APPENDIX C – RESPONSE TO GOVERNMENT ARCHITECT NSW

Table 1 – Design response to GANSW Commentary after SDRP – 1 (17.10.18)

Table 2 – Design response to GANSW Commentary after SDRP – 2 (12.03.19)

Table 3 – Design response to GANSW Commentary after SDRP – 3 (05.06.19)

DRAWING TITLE  
**PLAN - GROUND LEVEL**

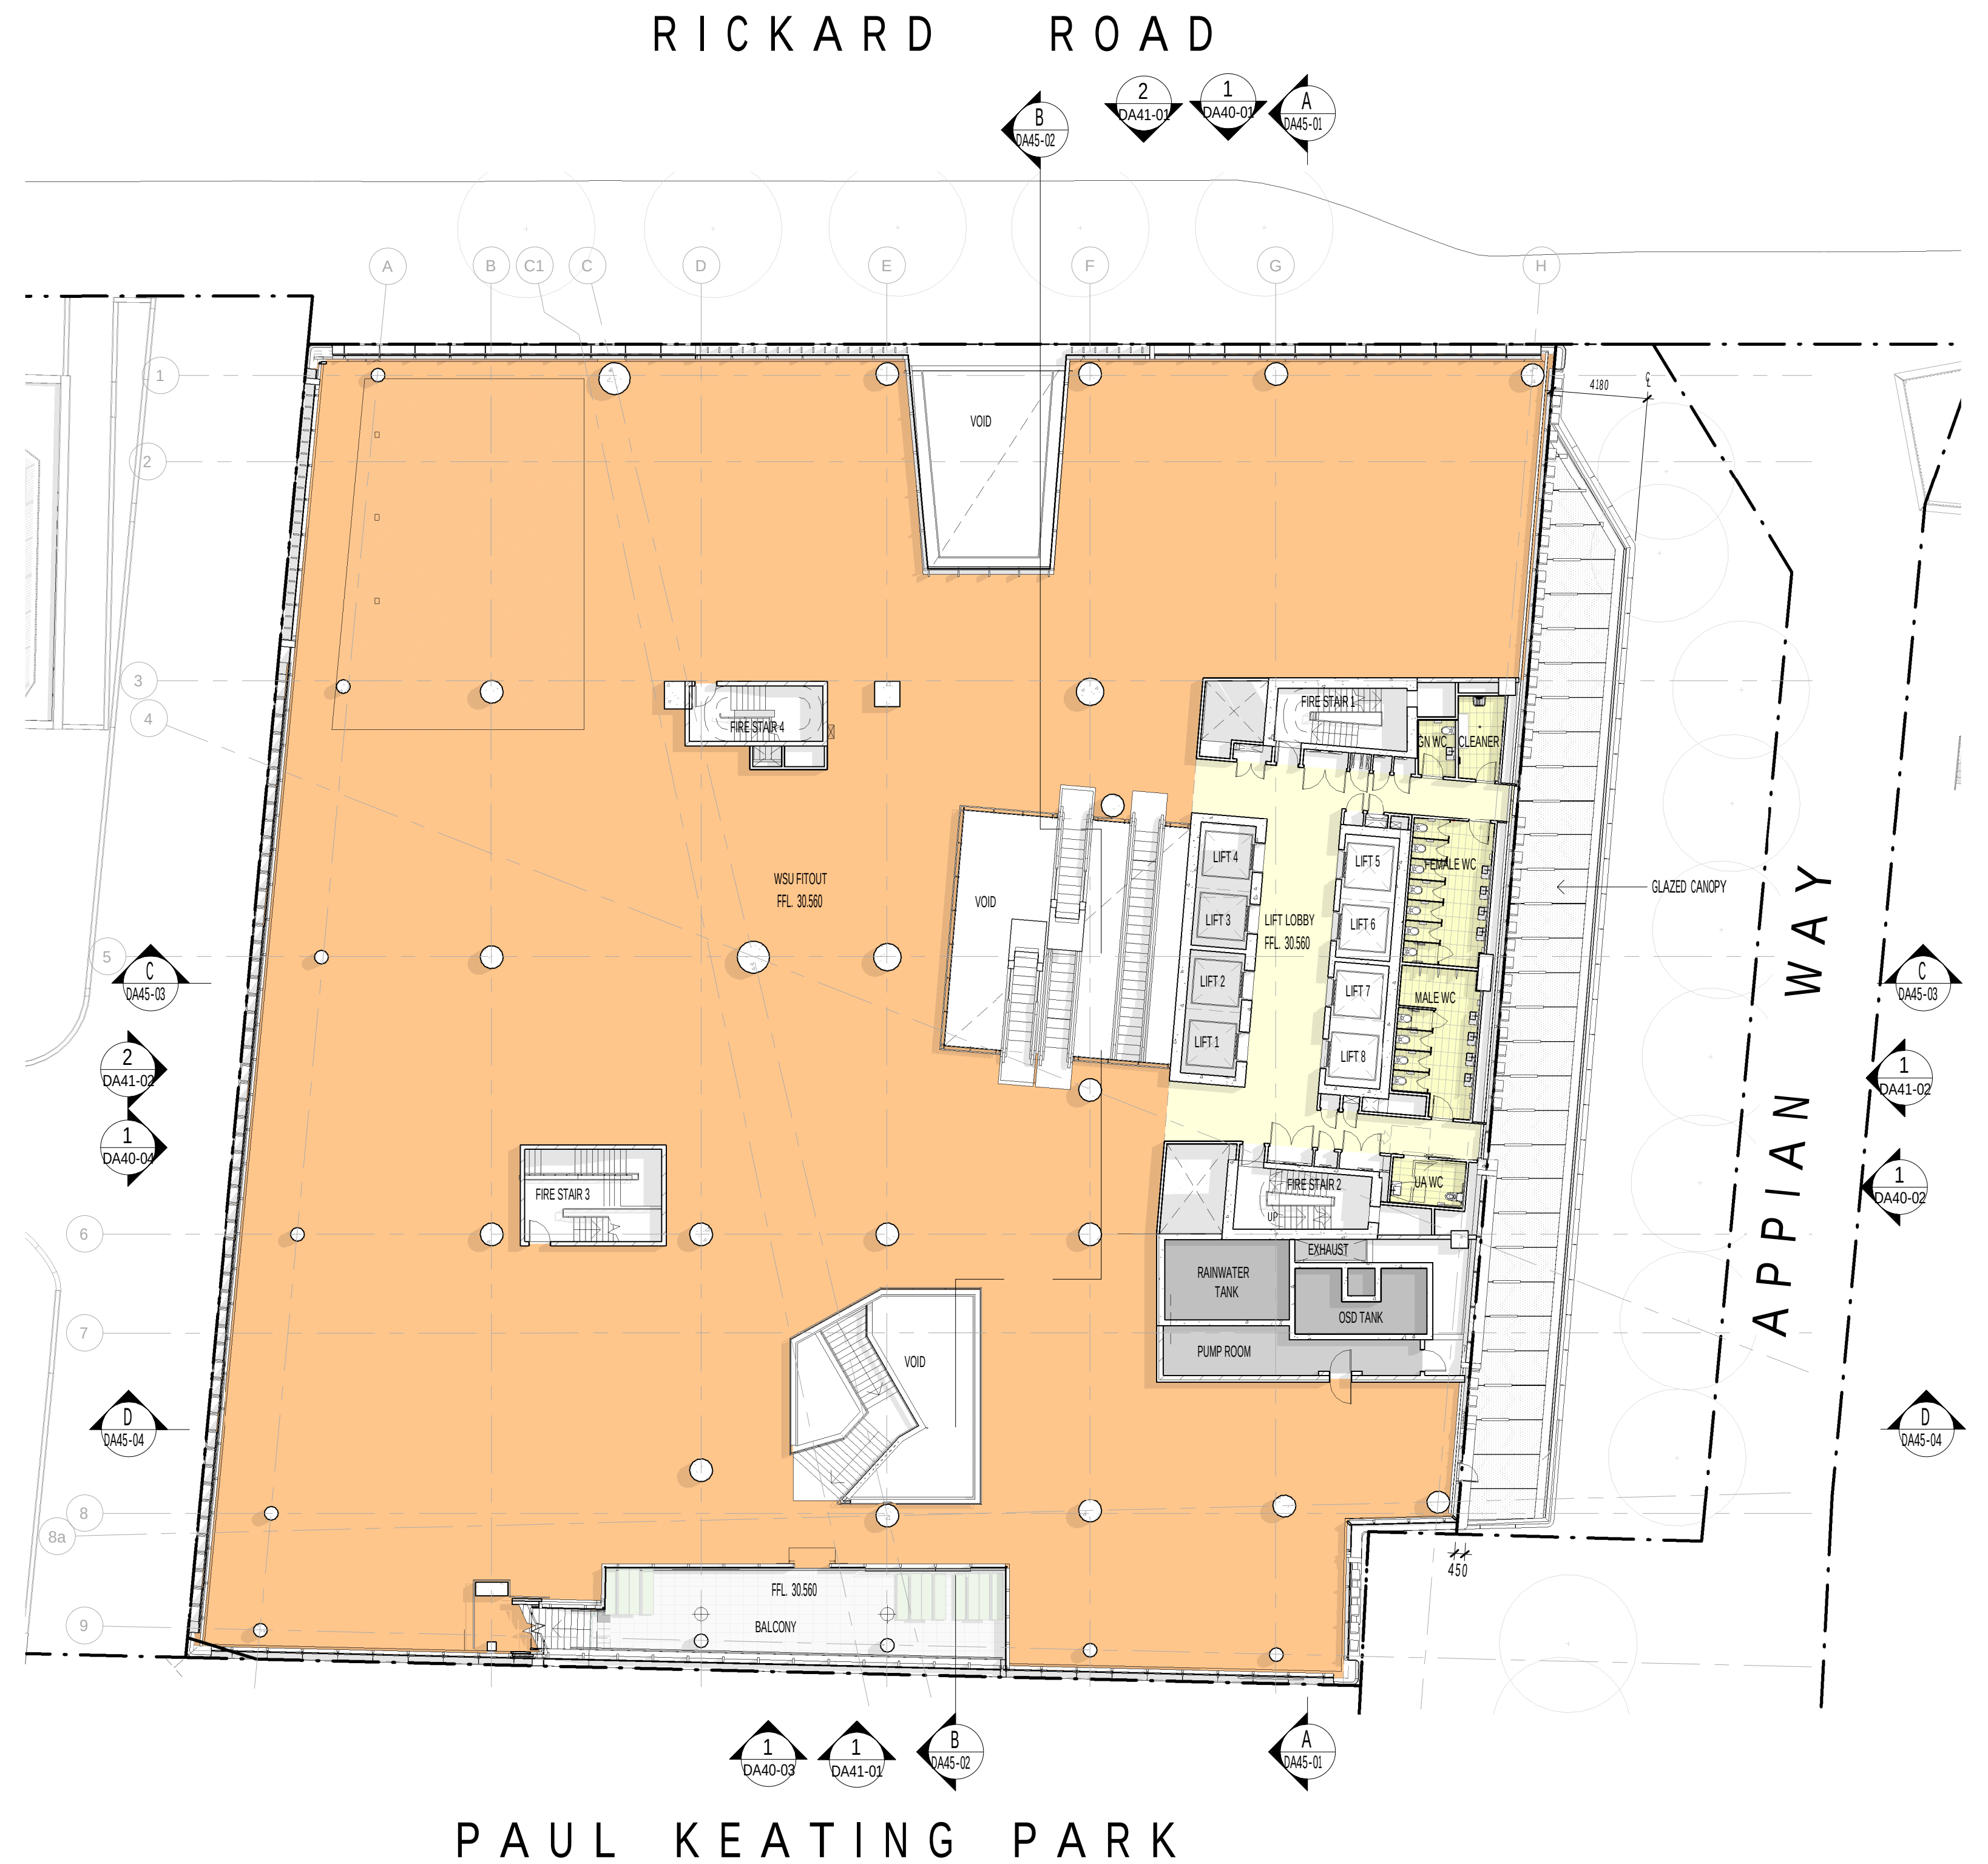
GANSW Commentary		Project Team/ Design Response
2.	A significant area of the ground floor fronting Appian Way is taken up by circulation cores. Ensure there is permeability and a good interface with the public domain in this area.	<p>The revised ground level layout and landscape design for The Appian Way responds to several functional and spatial constraints:</p> <ul style="list-style-type: none"> • Level changes, from a high point at the north west corner to a low point at the south west corner. • Imperative for seamless equitable access for all users. • Flood water levels at the building edge and adjoining the site, which must be managed to ensure flood levels and hazard are acceptable within the site and on adjoining or downstream properties. • Maintaining shared use of The Appian Way for vehicles and pedestrians. • Structural and vertical transport requirements for the building. <p>Within these constraints The Appian Way frontage comprises active retail spaces and entry foyer, with equitable access between the ground level and building entrances that are set above flood levels.</p> <p>Seating along the building edge will facilitate interactions between the building and activities in The Appian Way. Both physical and visual permeability has been provided.</p> <p>Refer to Section 3.3 and Appendices D and E for additional information.</p>
